**EPC STORMWATER REVIEW COMMENTS
IN ORANGE BOXES WITH BLACK TEXT**

**PCD-ENGINEERING REVIEW COMMENTS
IN BLUE BOXES WITH BLUE TEXT**

FINAL SITE GRADING CONSTRUCTION PLANS
FOR

FINAL GRADING / EROSION CONTROL PLANS

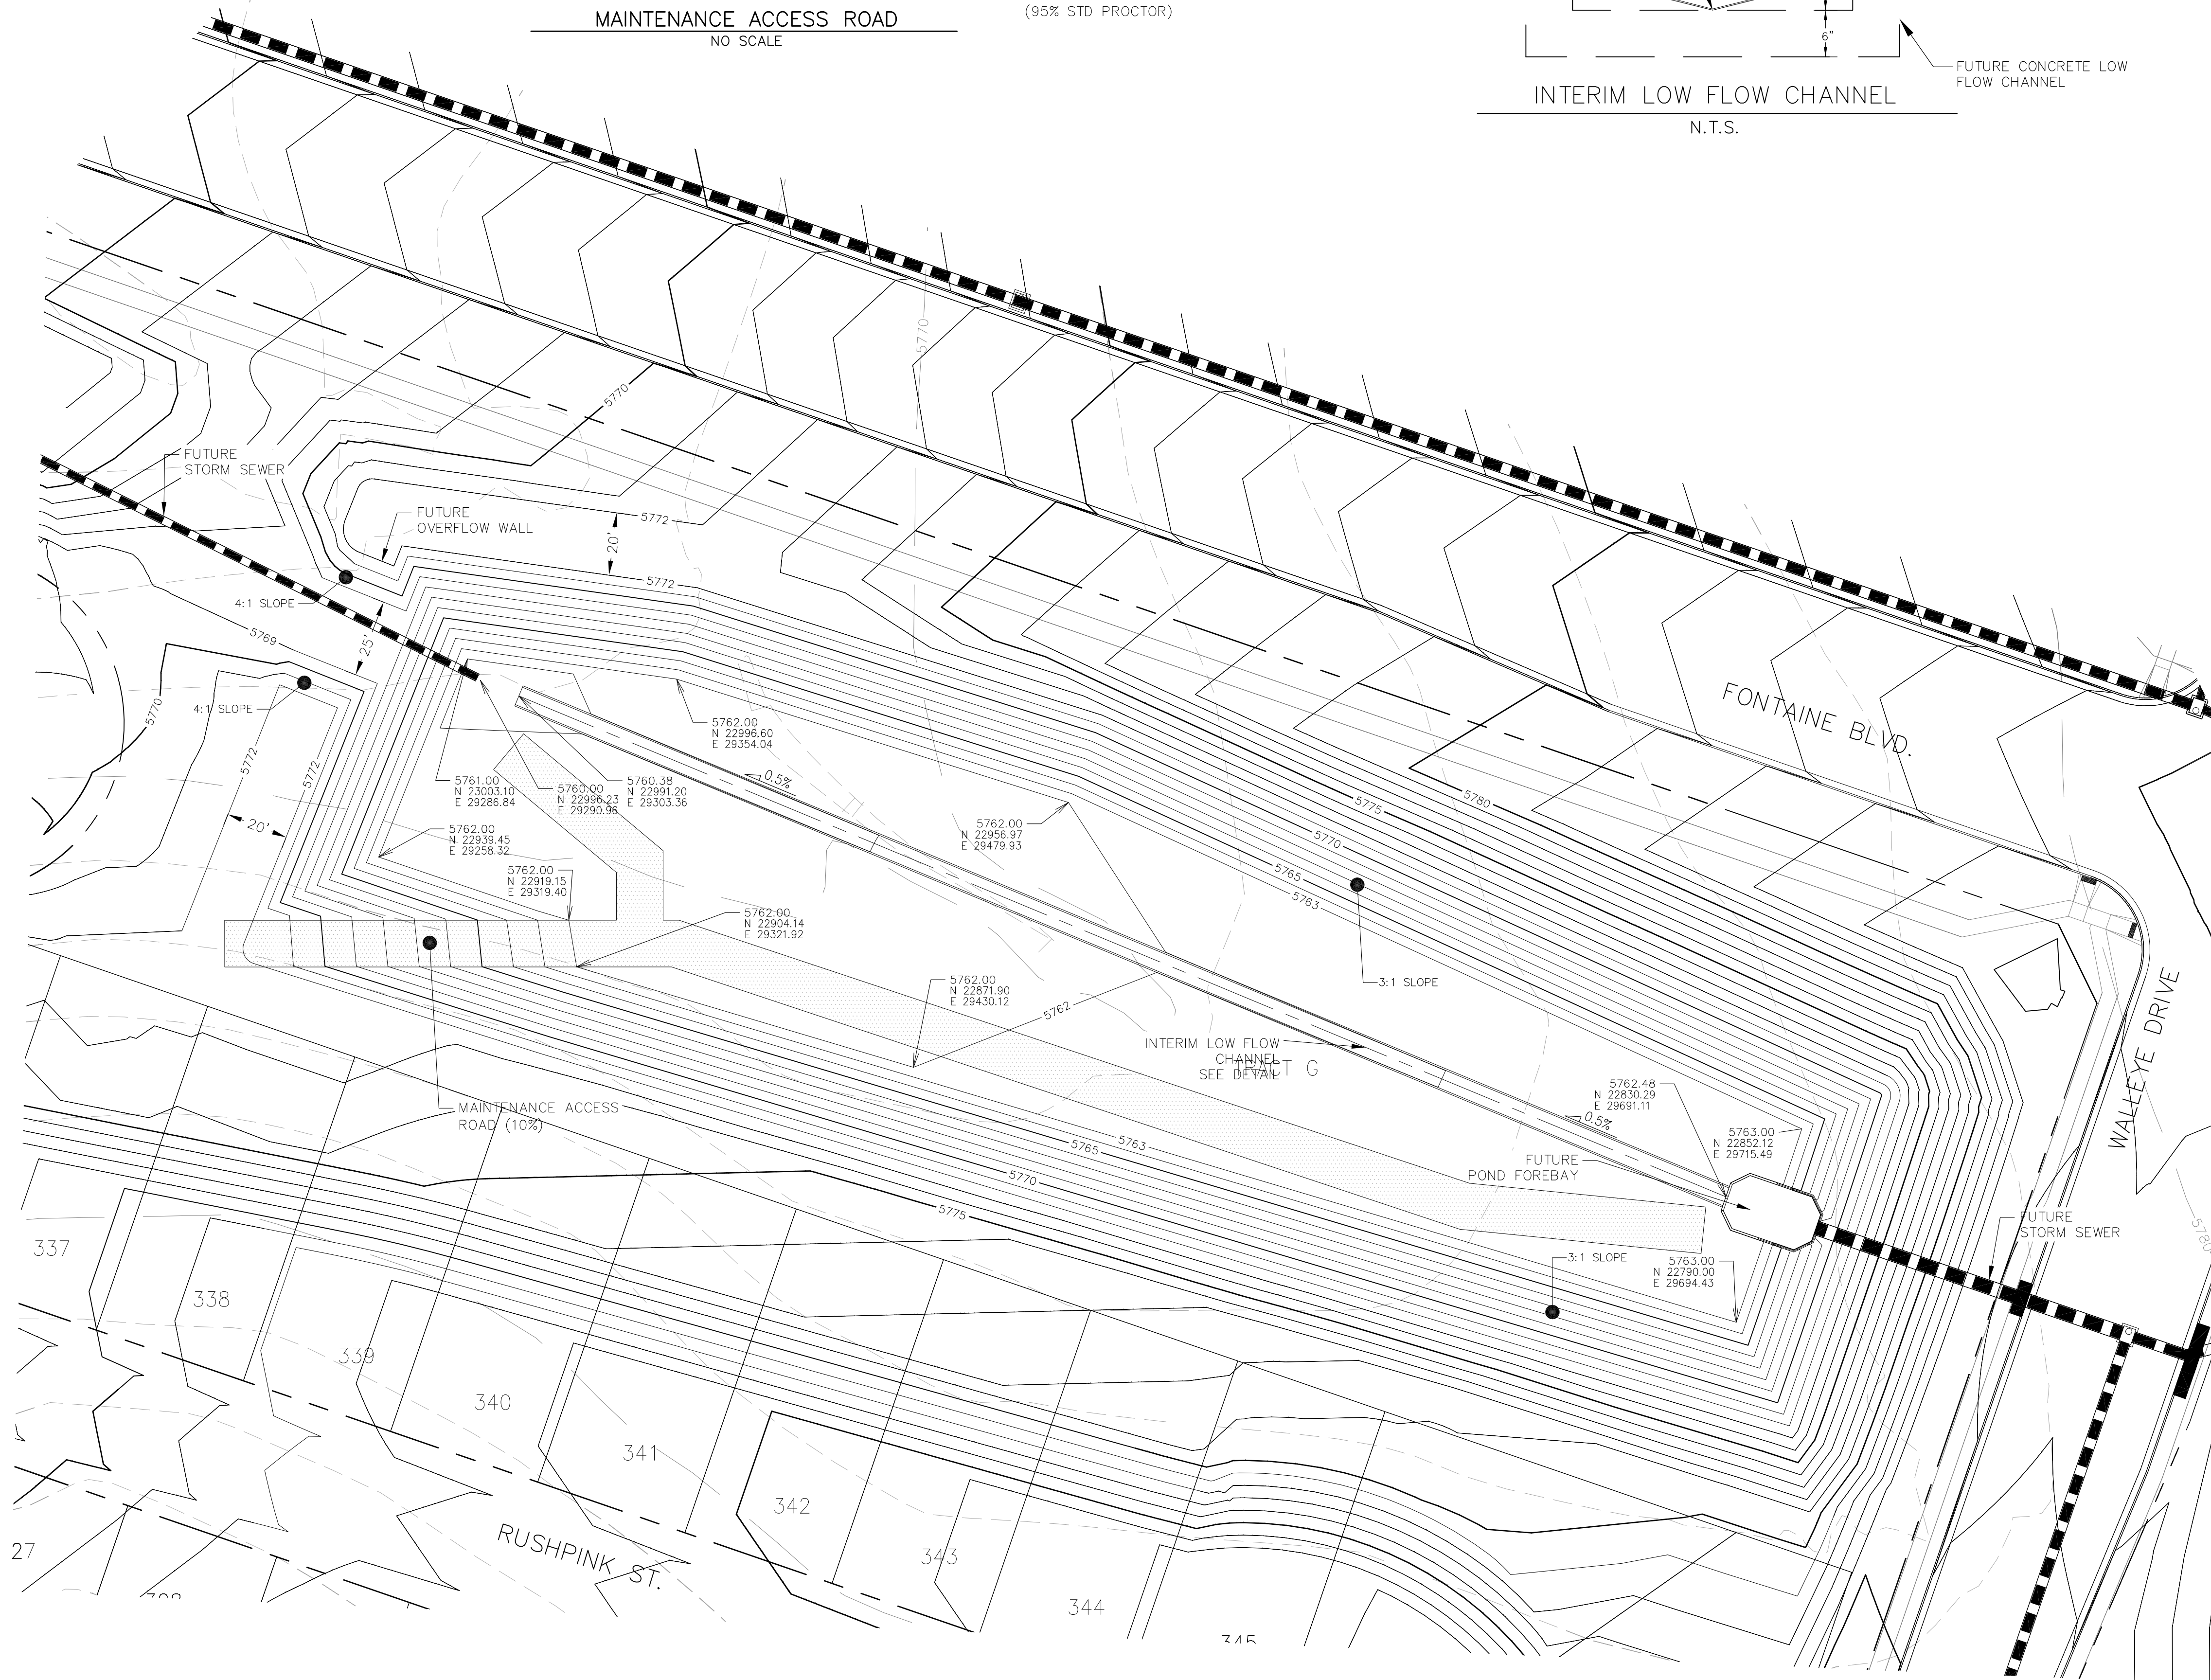
Is this sheet being revised from EGP plans? If not, reference the EGP plans with a note on the cover sheet.
